6 May 2019

Re Bayside Council Response to F6 Extension Stage 1 Preferred Infrastructure Report and Response to Submissions Report: SSI 8931

Figure 9.5: Civic Avenue / President Avenue Configuration

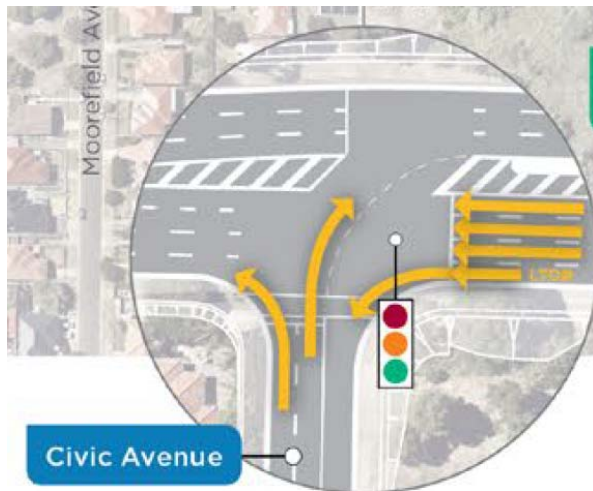
The Preferred Infrastructure Report does not demonstrate or mention the provision and/or the length of a holding lane in President Avenue for traffic that turns right out of Civic Avenue. This holding lane is required to allow traffic from Civic Ave to merge safely with traffic travelling in President Avenue. Council request confirmation that this holding lane will be included as part of this project.
